Subject: Re: Application 54873/APP/2020/721 HUME WAY RUISLIP

Rebecca (Yuen) Lo
Planning Officer

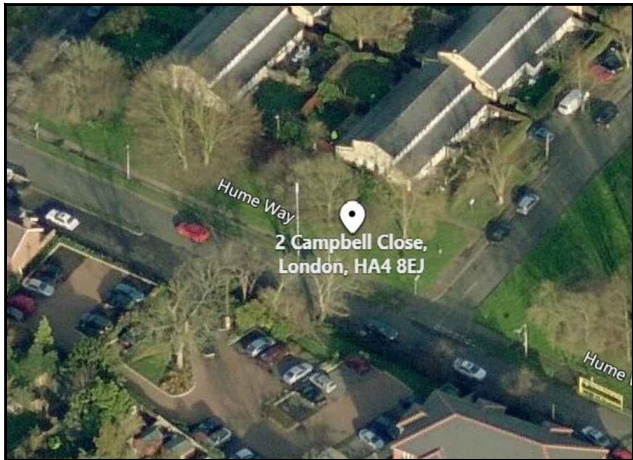
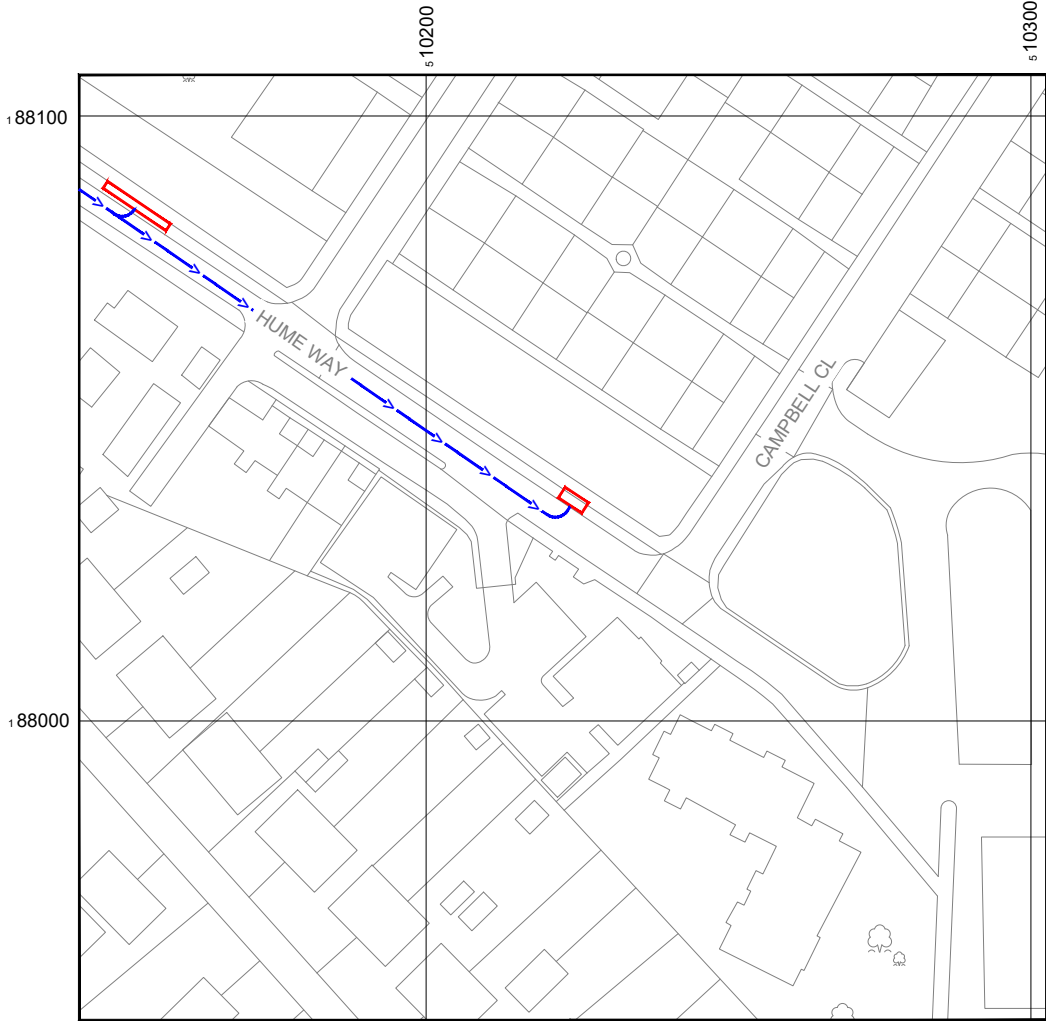
I am the planning officer for this application. The application is valid however, would you be able to amend plan **002 Site Location Plan Issue. B** and label which site is proposed and which is existing? Public consultation will begin shortly therefore, I wish to have this amended beforehand to avoid any confusion from the public.

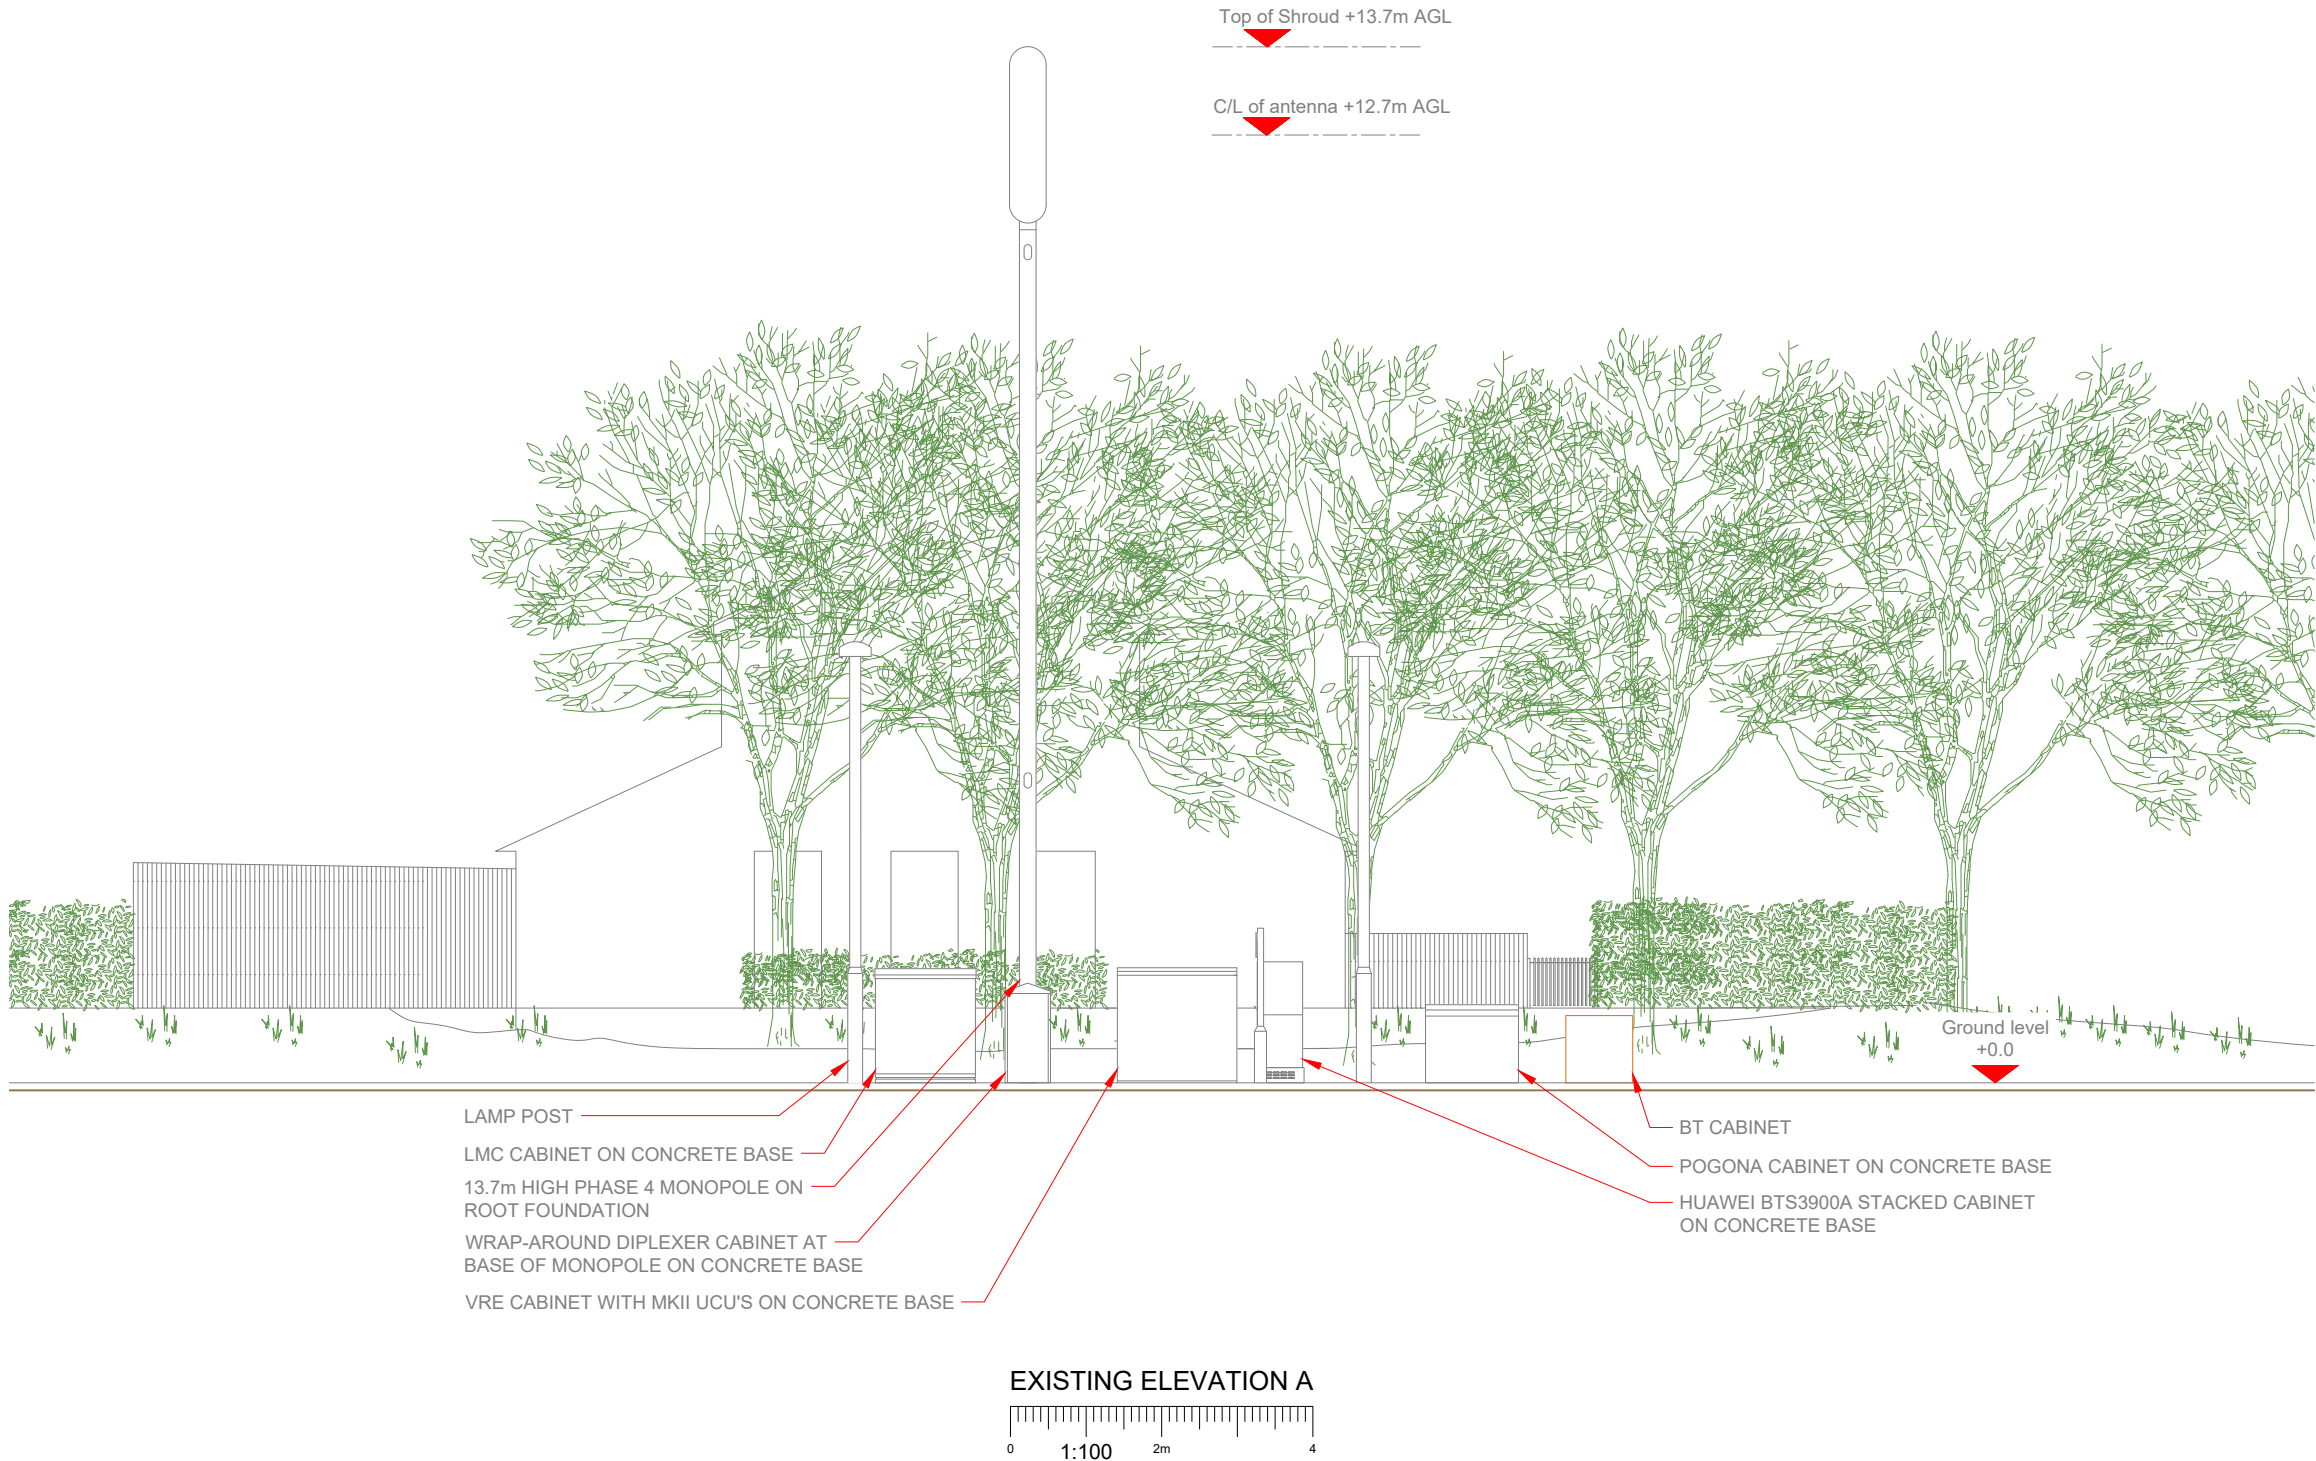
Plan 216 Max Configuration Site Plan - sheet 2

- The width of the grass verge in which the proposed is located reduces in size towards the north-west - please amend plan to show this.
- Foliage of the trees appears much wider on site - the location of the monopole appears to conflict with an existing tree which can clearly be seen even on the aerial of google map.
- Location of the trees on the plan does not match what is on site.
- Can you confirm if the grass verge is 2m? Based on my site visit and google map, it appears to be less than 2m.

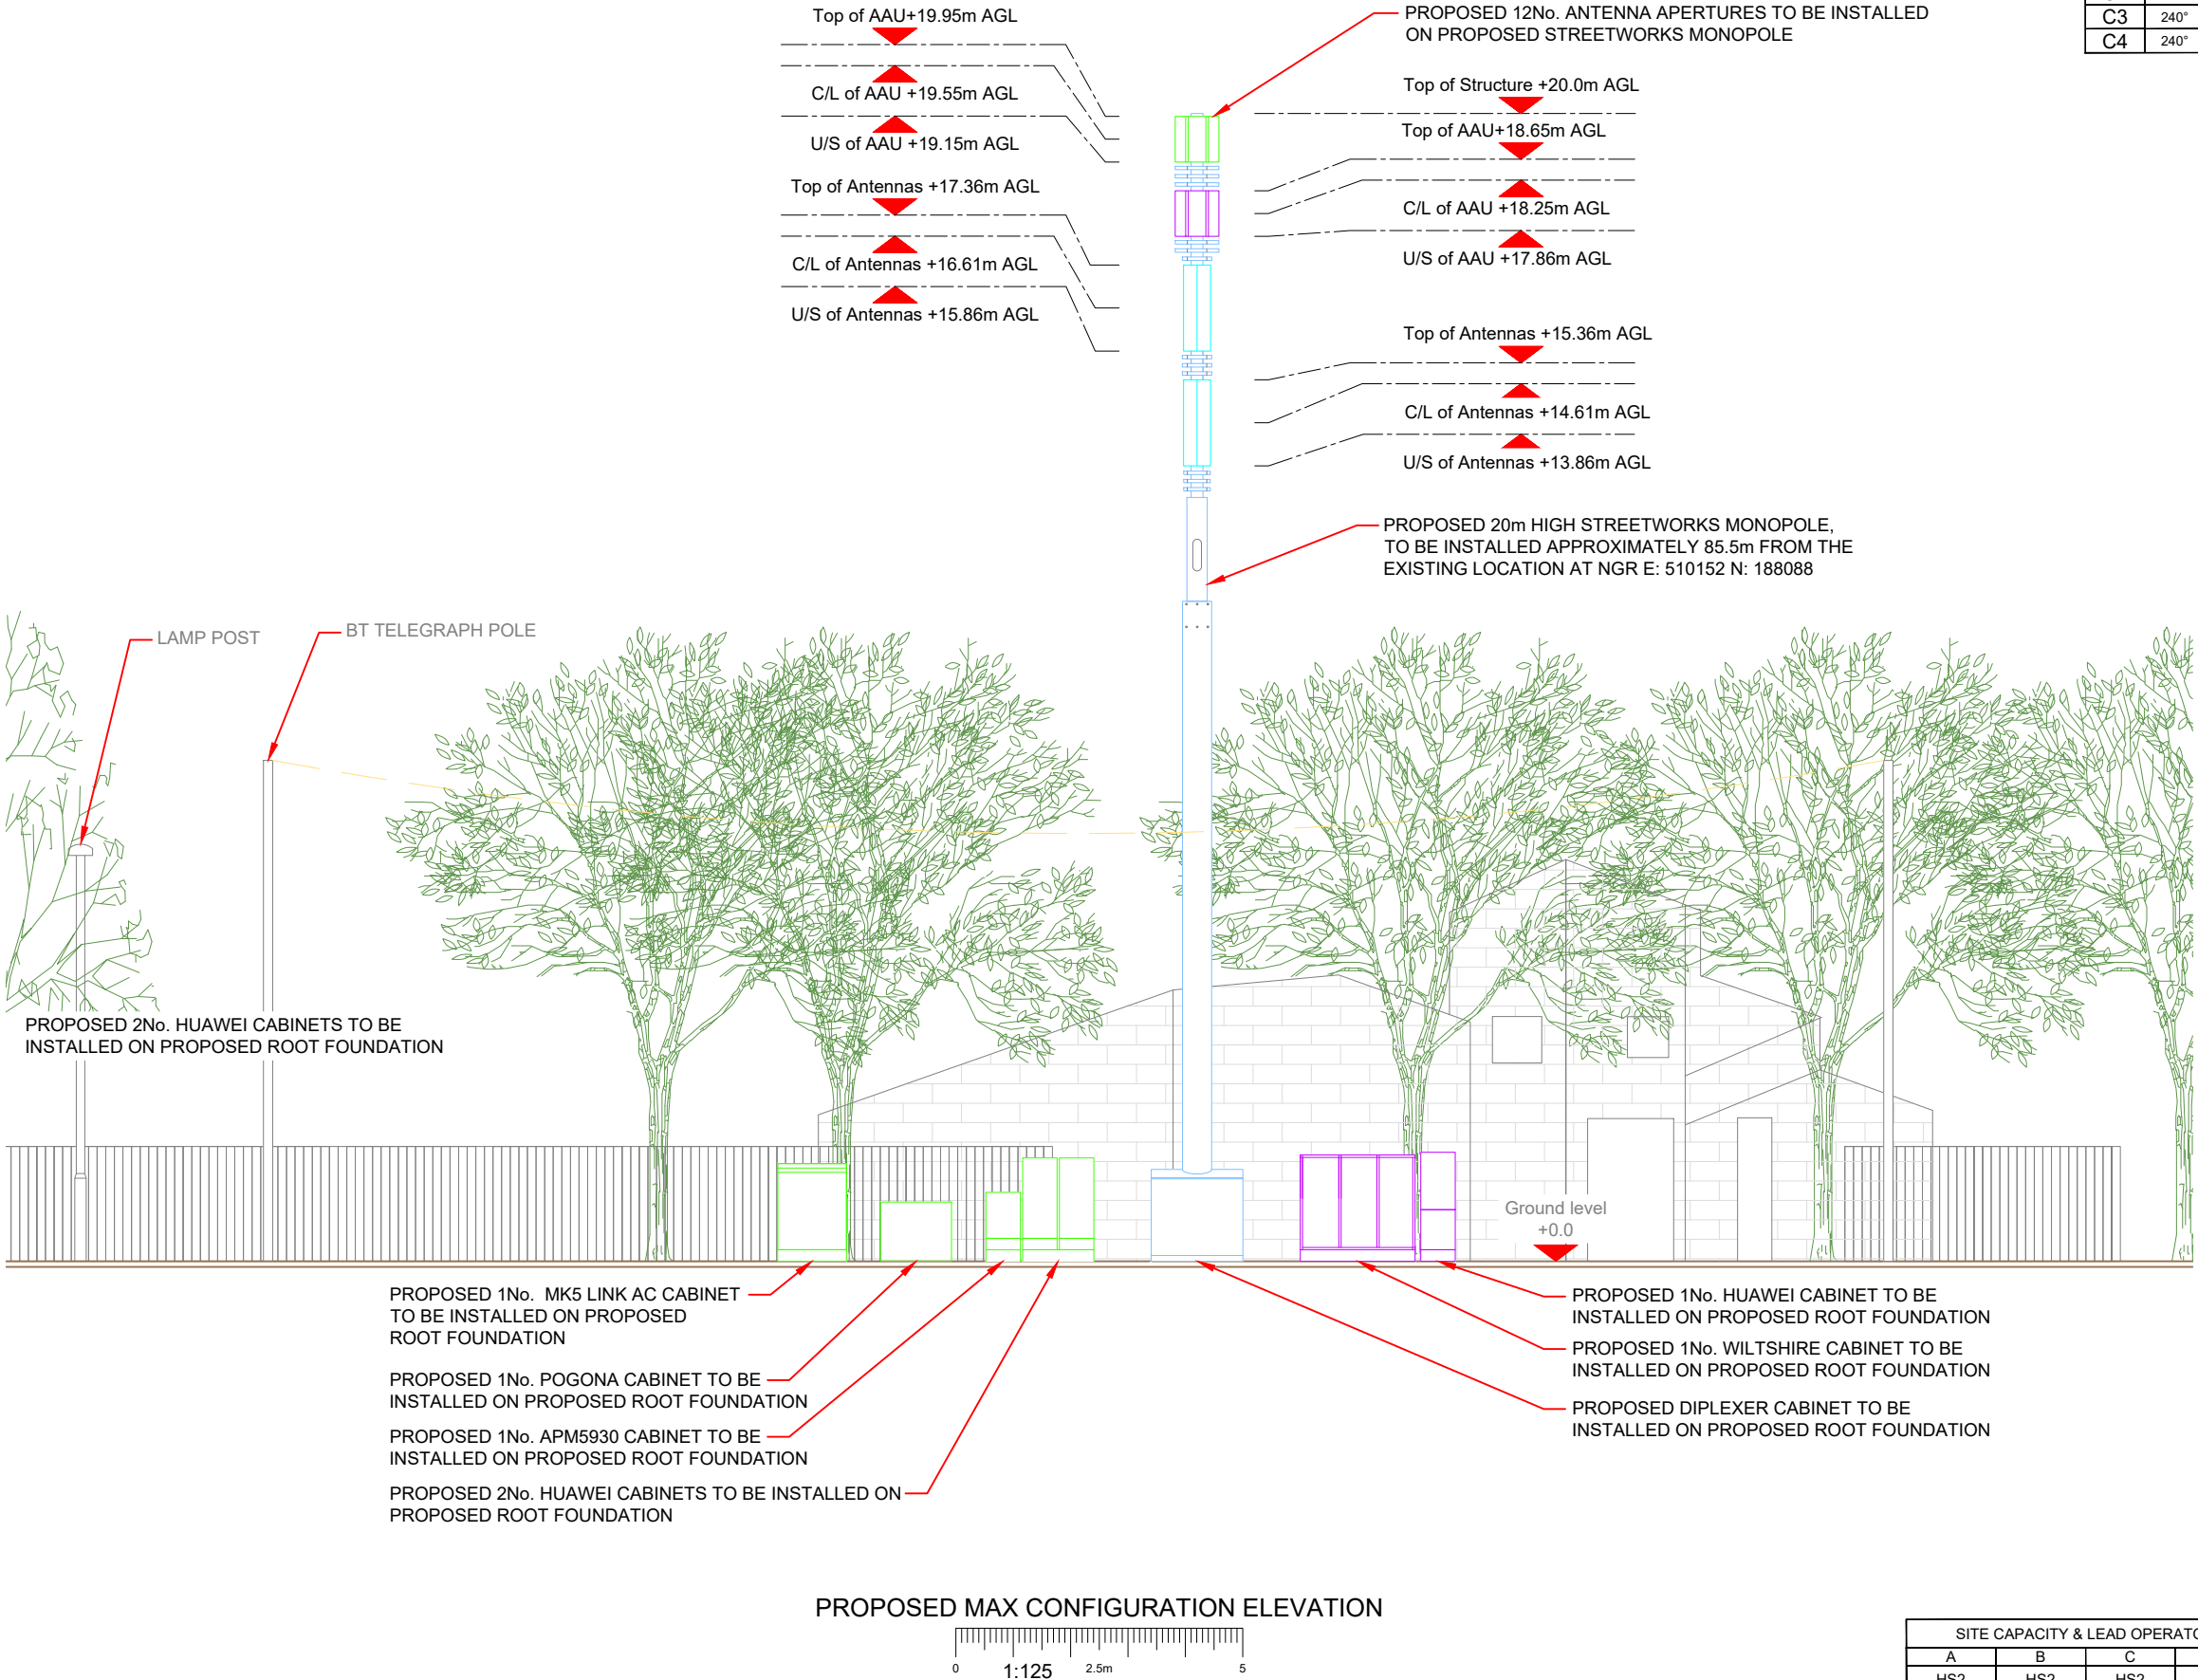
Plan 266 Max Configuration Elevation - Sheet 2

- There is an existing telegraph pole with wires adjoining properties across the street, which is absent from the drawing - will this interfere with the proposed?
- Scale of the drawing appears to be incorrect
